**OS Parcel 9100 Adjoining And East Of Last  
House Adjoining And North Of Berry Hill Road  
Adderbury**

**22/03437/DISC**

**Proposal:** Discharge of Conditions 14 (arboricultural protection), 17 (landscaping), 18 (landscape management) and 20 (air quality assessment) of 19/00963/OUT (granted consent under appeal Ref: APP/C3105/W/20/3255419)

scale: 1:200@A1
drawing no: HAY23648-11D Sheet 3 of 3

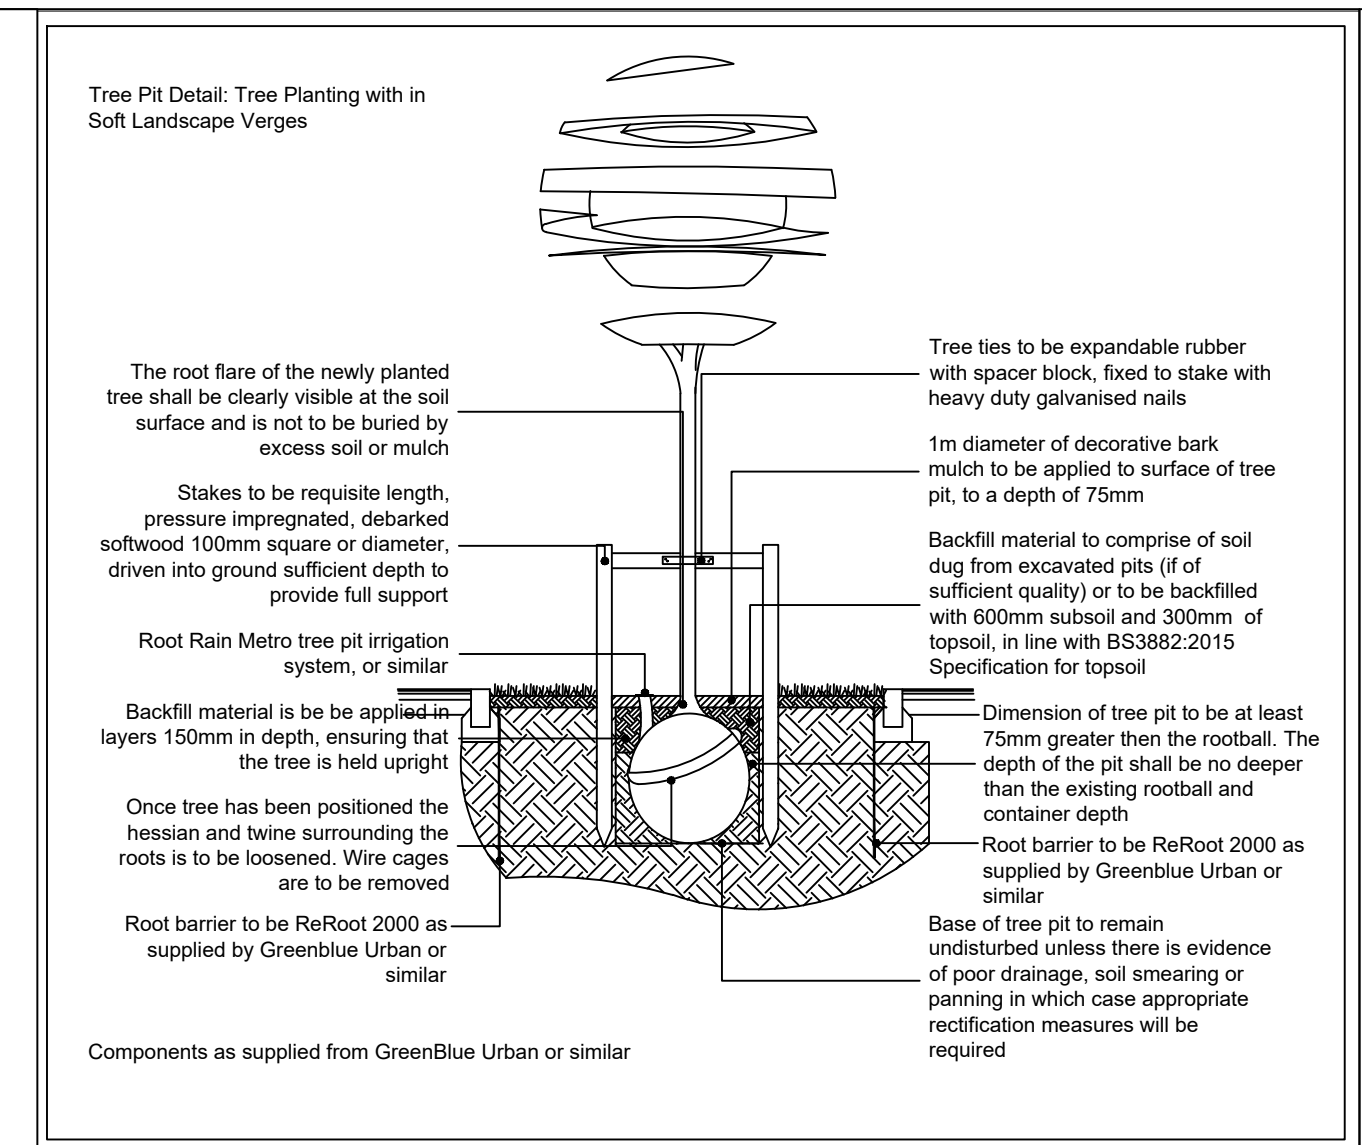
- 5.1. Cherwell District Council's Arboriculturist – The tree protection plan is fine. The proposed tree planting looks to me to be pretty boring. The majority of the proposed planting is native but not entirely. It would be good to see more large specimens being planted and also the inclusion of some more exotic trees. As well as at least some non-deciduous species.
- 5.2. Cherwell District Council's Landscape Officer – Following additional information, I am pleased to confirm my acceptance of the LAP details.

- 6.3. Conditions 17 and 18 relate to landscaping and landscape management. The Landscape Officer was consulted and following the submission of amended details, the proposals were deemed acceptable. The details are therefore considered to be acceptable and provided the agreed works are carried out, the conditions can be discharged. Trees have also been included within the garden areas to reduce overlooking to the neighbouring properties to the west.
